SSD-8950984: Response to Submissions for the Burrendong Wind Farm Project

The information provided in the Response to Submissions (RtS) Amendment Report does not adequately address all TfNSW's previous requests for information, and TfNSW has requested further information following its review of the updates to the Traffic Impact Assessment (TIA) and changes to the project scope.

TfNSW's key rationale for requesting information is to demonstrate that the designs comply with Austroads, establish the scope of works, and mitigate the project's impacts on the state road network from a safety, efficiency, and asset management perspective.

DRAWING TITLE:
**STRATEGIC DESIGN
 SID PLAN**

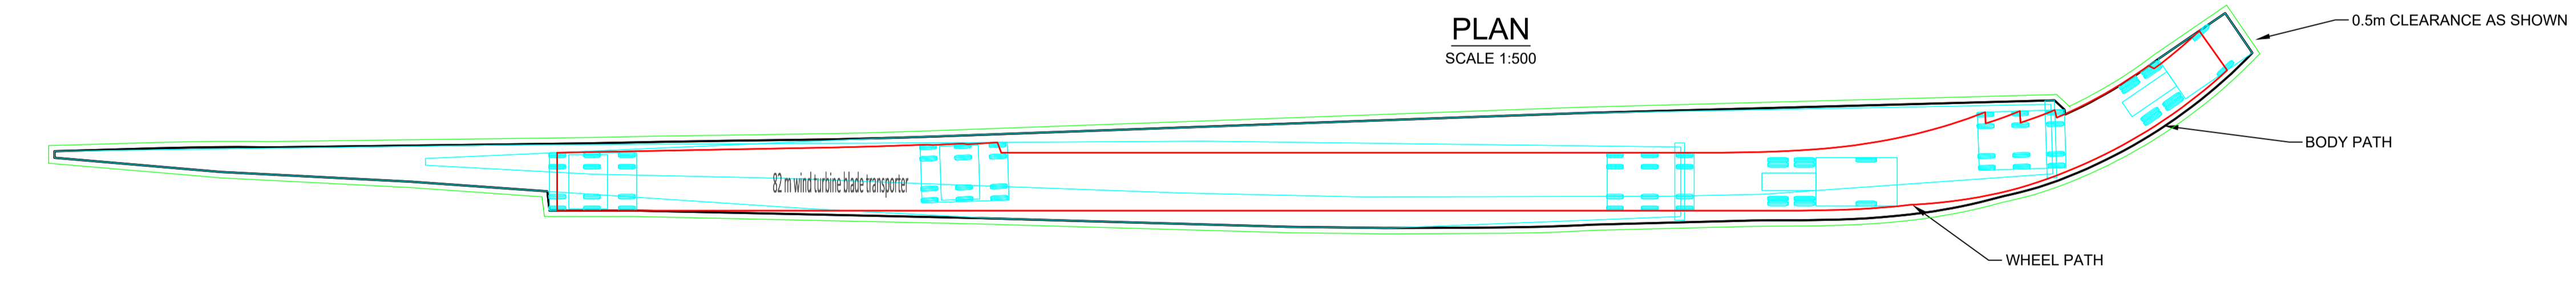
9.	BAR Dimensions: The current proposals show a widened shoulder of 3.0m. If Goolma Road is a type 1 or type 2 approved route, this width should be 3,5m shoulder. If there are no Road Trains, then this is no issue. Refer to the Austroads Guide to Road Design, Part 4a, Fig 7.1. This comment relates to the dimensions of the proposed BAR treatment. This can be addressed in 2 ways: if the route is an approved type 1 or type 2 road train route, the BAR dimensions need to be increased to meet that standard. If it is not an approved route, the proprietor can respond accordingly after investigating and providing evidence.

10.	How will traffic be managed on the new Hardstand areas provided? In terms of prohibiting unwanted parking or stopping in this area? In the same vein, how will traffic be managed to prevent undesirable left turns out of Twelve Mile Road, cutting the corner and using the hardstand area to "shortcut" the intersection? This comment needs to be addressed and should highlight the proposed treatments or controls to prevent unwanted or undesirable movements in these hard-stand areas during the installation of the wind farm.

11.	Verge, batter, and table drain details must be included in all proposed strategic concept designs. It will be important to show how drainage will be managed at these intersections. Additional information is sought regarding the road formation and footprint. There are no shoulders or verges provided, nor any batters or table drains. Survey data will need to be collected to enable the designers to model all of this.

DRAWING TITLE:
**STRATEGIC DESIGN
SWEPT PATH PLAN - OSOM VEHICLE**

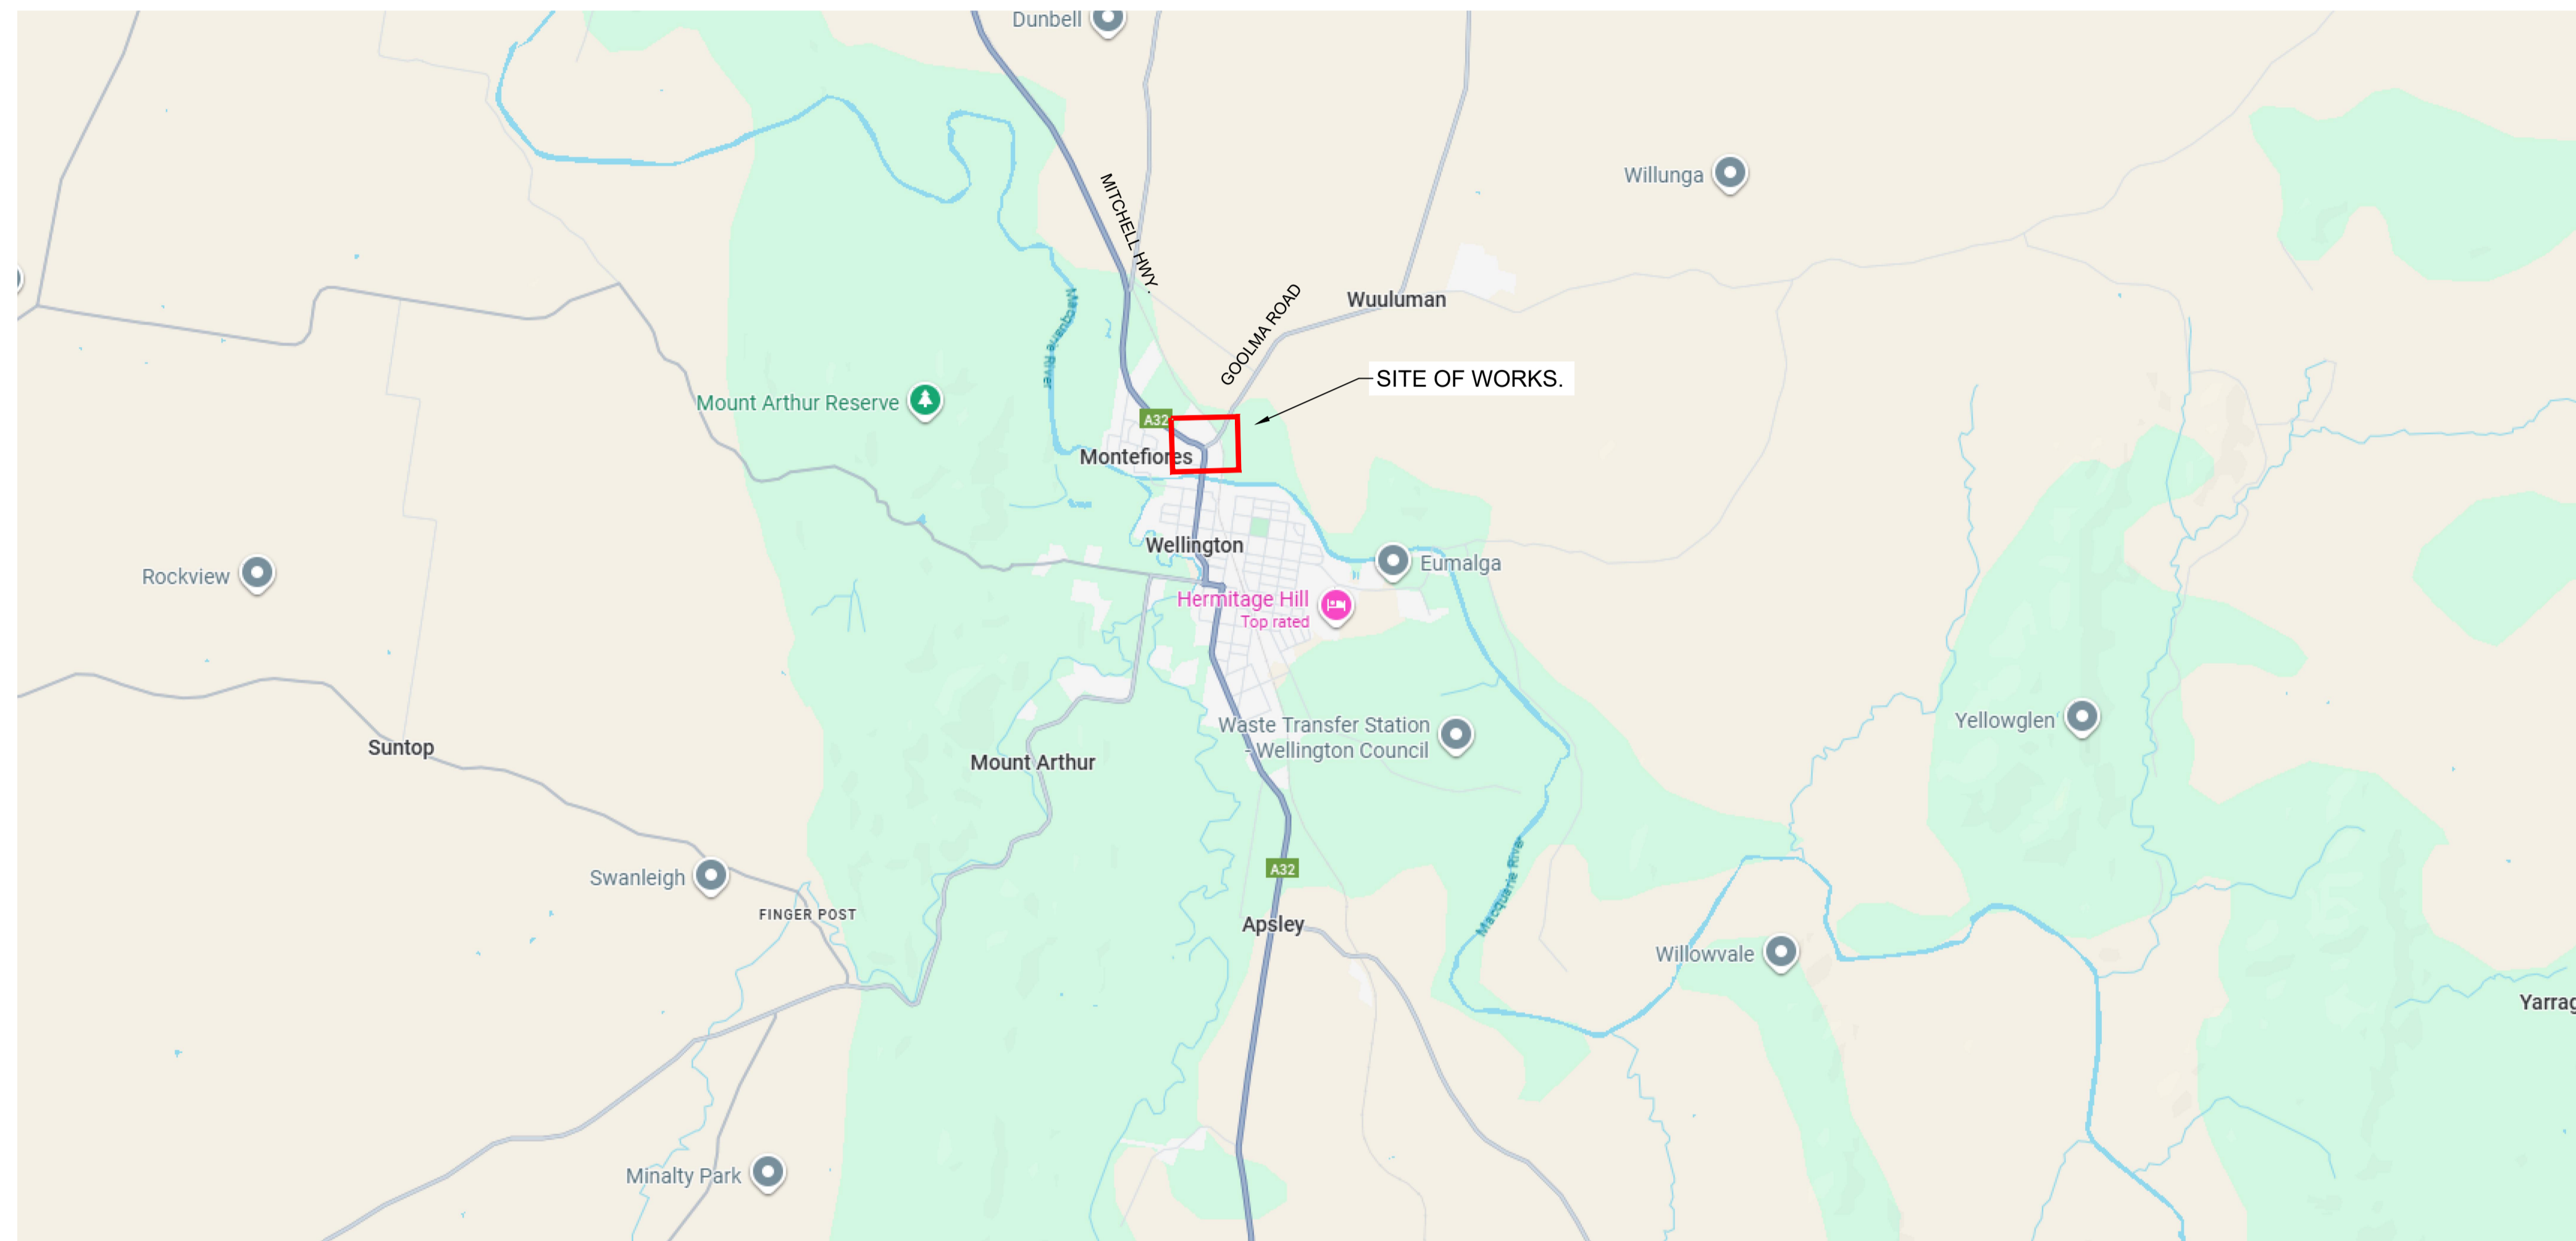
7	The submitted intersection strategic concept designs are inconsistent with the swept path analysis presented in the Rex J Andrews route analysis, which identifies the requirement for a larger hardstand widening, for example, Figure 27- Goolma Road onto Twelve Mile Road compared to the scope of the hardstand widening identified for the same intersection in the Appendix H_2 Intersection strategic designs.
---	---

The swept path analysis for each intersection requiring widening, specifically for the high-risk OSOM turning movements on the state road network and for intersections outlined within the Rex J Andrews route analysis pertaining to Burrendong Wind Farm, must undergo a cross-verification process against the Appendix H_2 Intersections strategic designs. This is to ensure that the designated hardstand aligns accurately with the wheel path of the high-risk OSOM design vehicle configuration. In instances where discrepancies are identified, the strategic concept designs are to be revised accordingly to achieve consistency with the swept paths detailed in the Rex J Andrews route analysis.
8	Referring to a 'hard stand' or planning to use a non-pavement hardstand is not acceptable. A properly designed pavement solution is necessary due to the project's construction timeframe, OSOM loading, including turning movements, and the need for ongoing maintenance during and after construction. Additionally, consideration of potential erosion and environmental impacts is required. Temporary pavement solutions are not acceptable and will not be supported by TfNSW. Relevant details addressing these requirements should be provided and updated within the strategic concept design package.
